TfNSW Reference: SYD15/01390/29
Departments Reference: SSD 7348 MOD 6

SECTION 4.55 (1A) MODIFICATION TO APPROVED OAKDALE WEST ESTATE - WAREHOUSE & DISTRIBUTION FACILITY - ERSKINE PARK

MOD 6

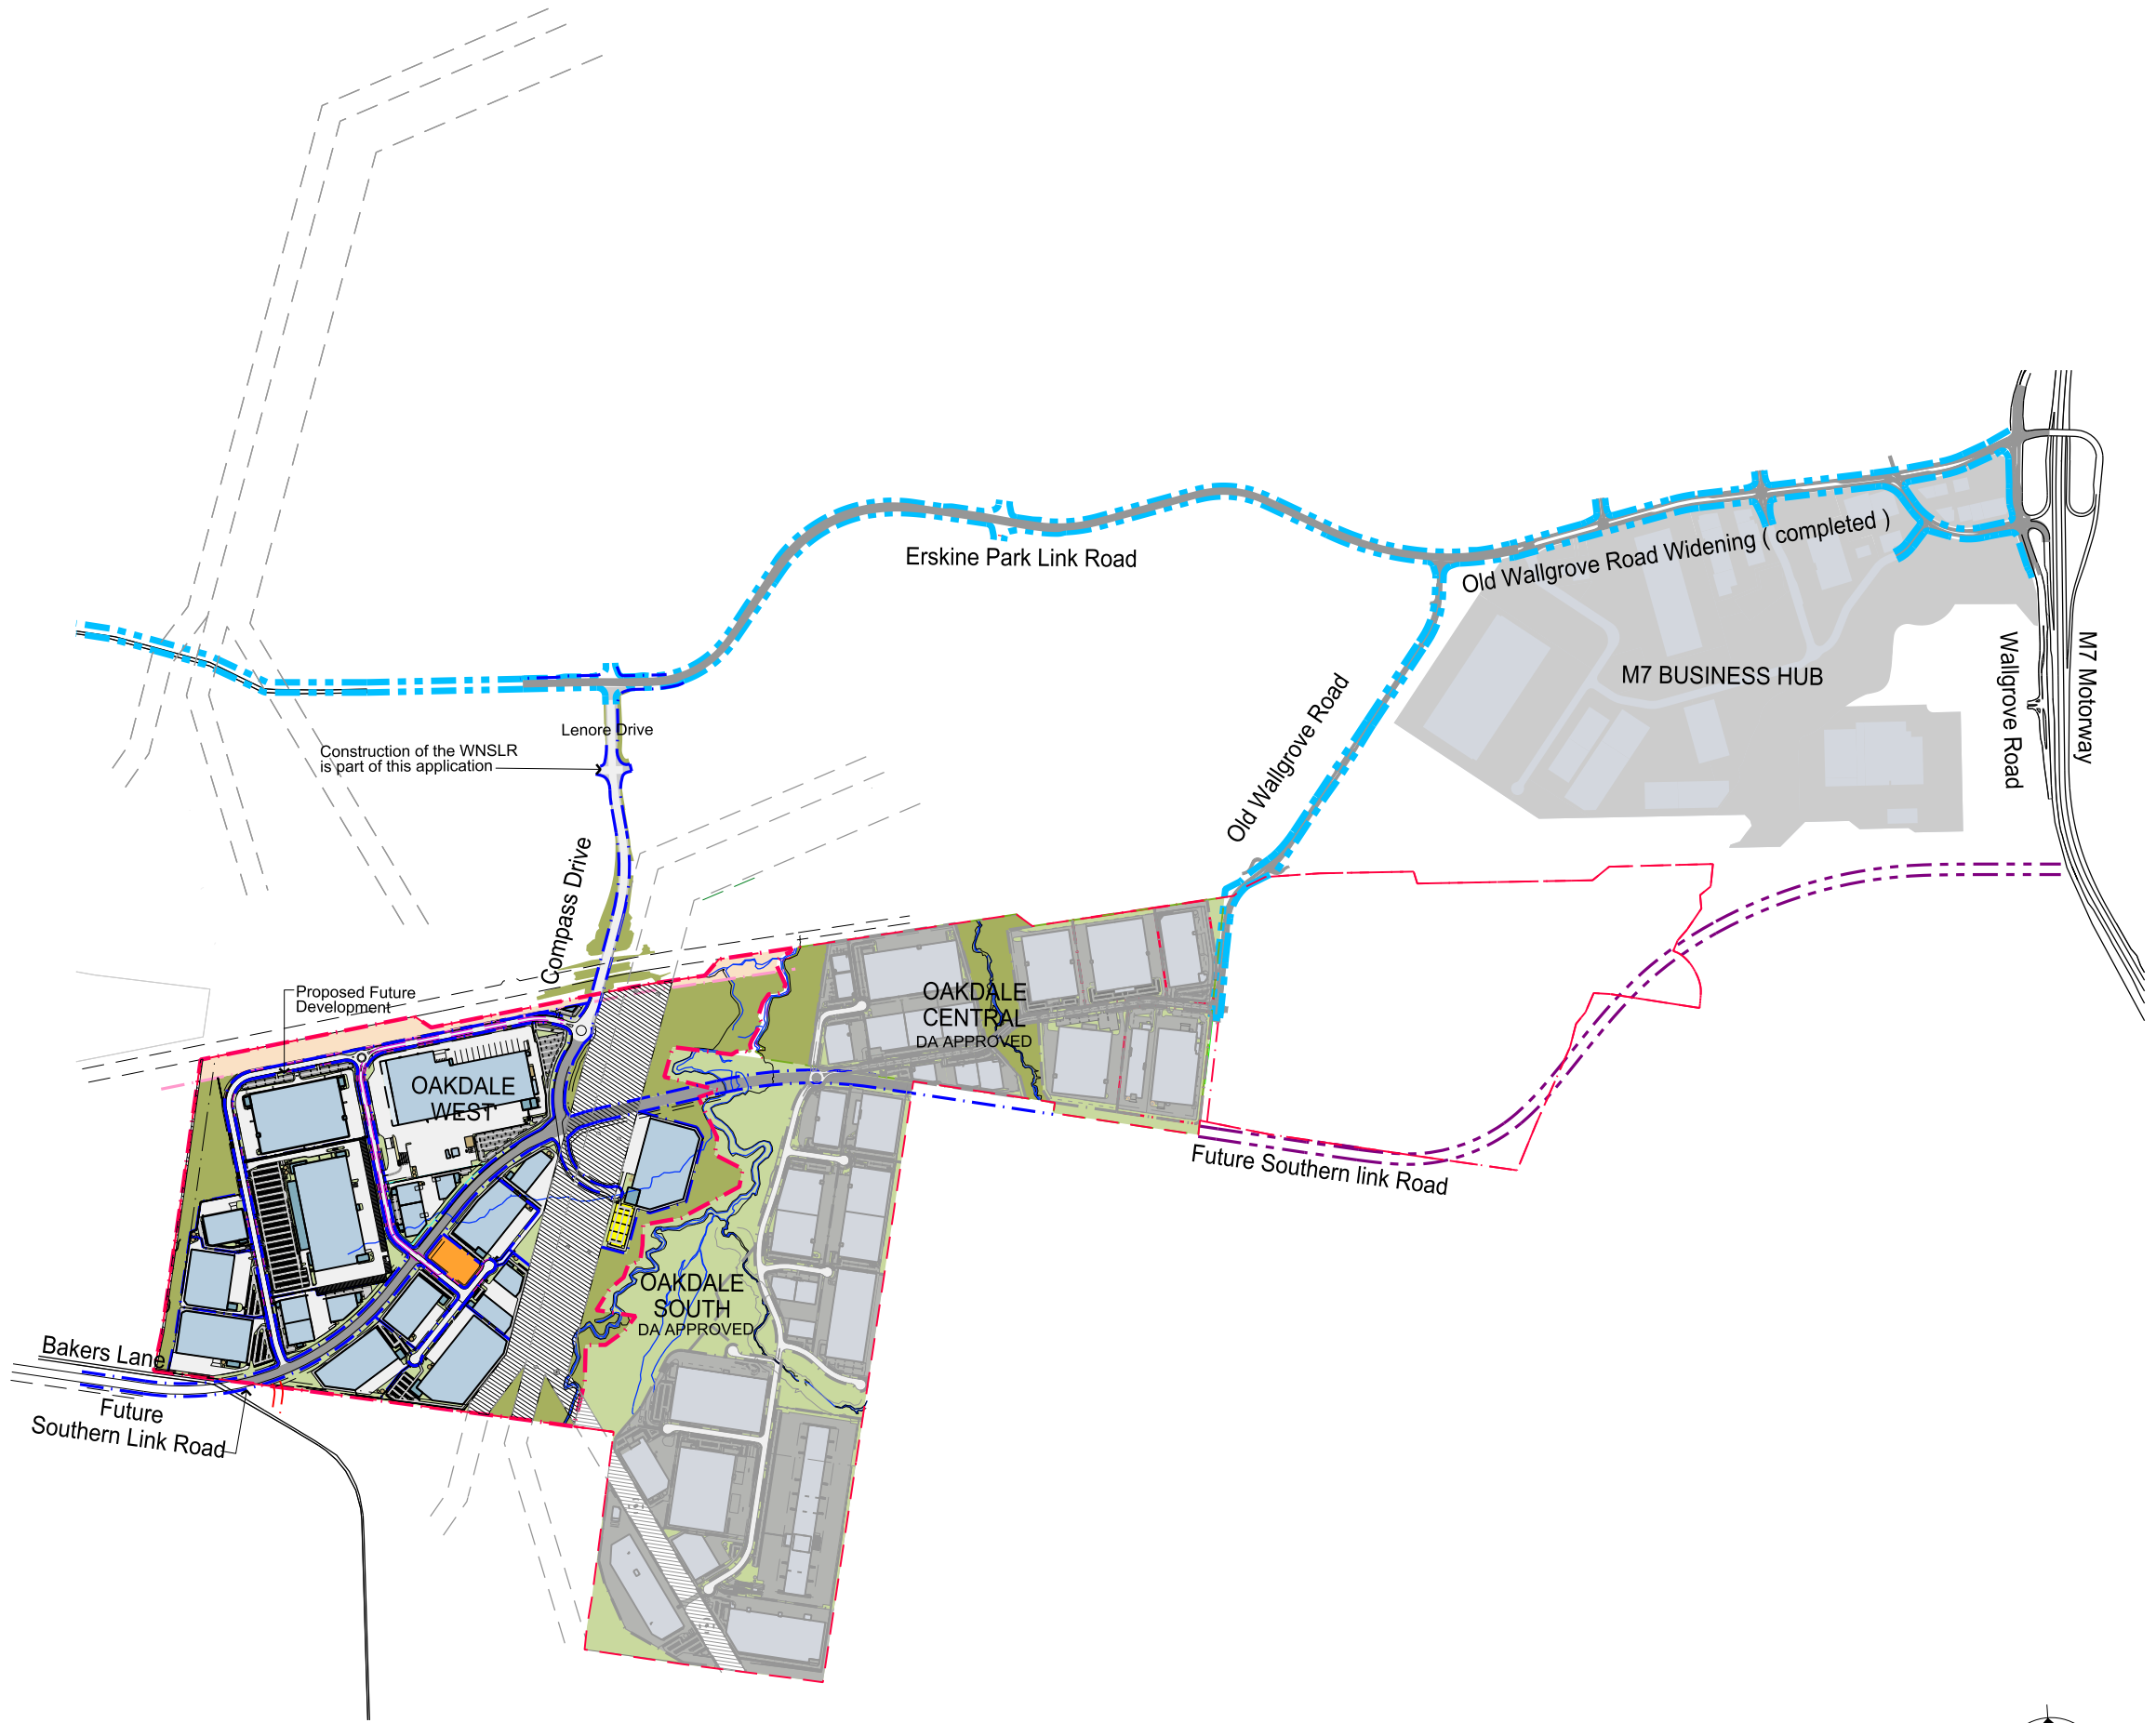
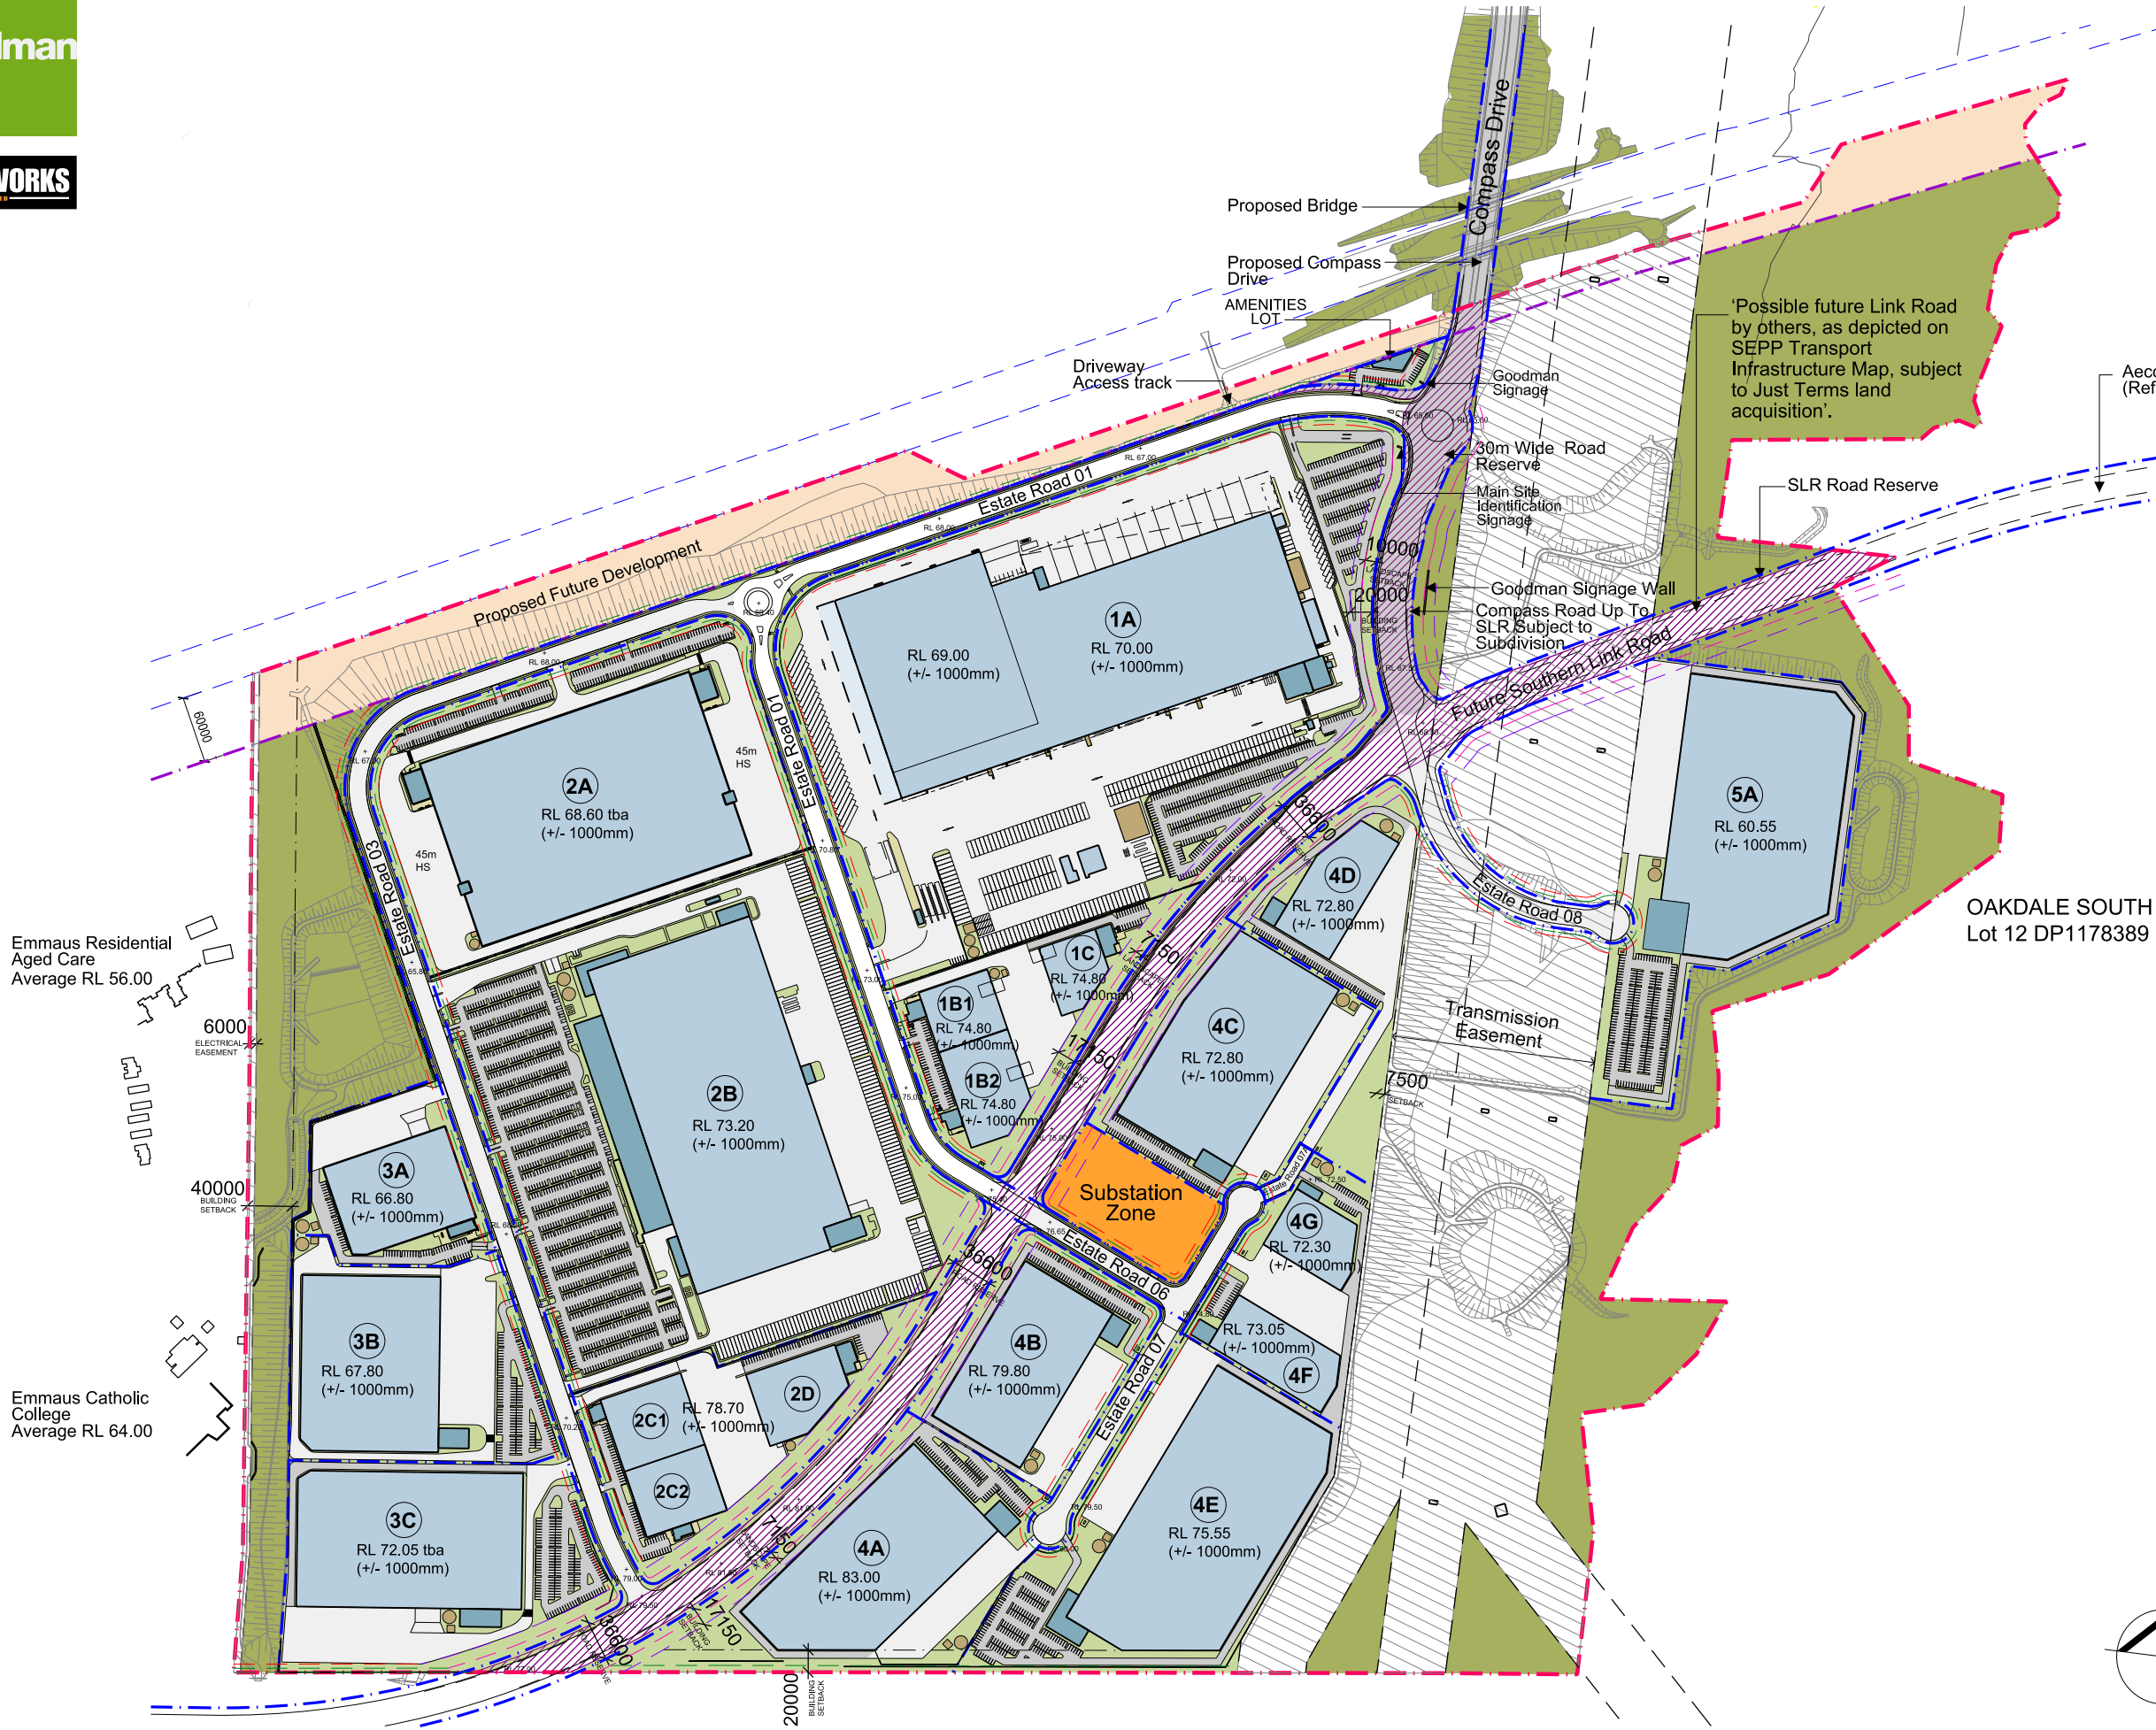
The lack of clear marking or labelling of the Gazetted Western Sydney Freight Line (WSFL) as SP2 on the maps makes it difficult to identify the impact on the proposed WSFL corridor.

TfNSW requests the maps be updated to identify the Gazetted Western Sydney Freight Lines as SP2 for clarity.
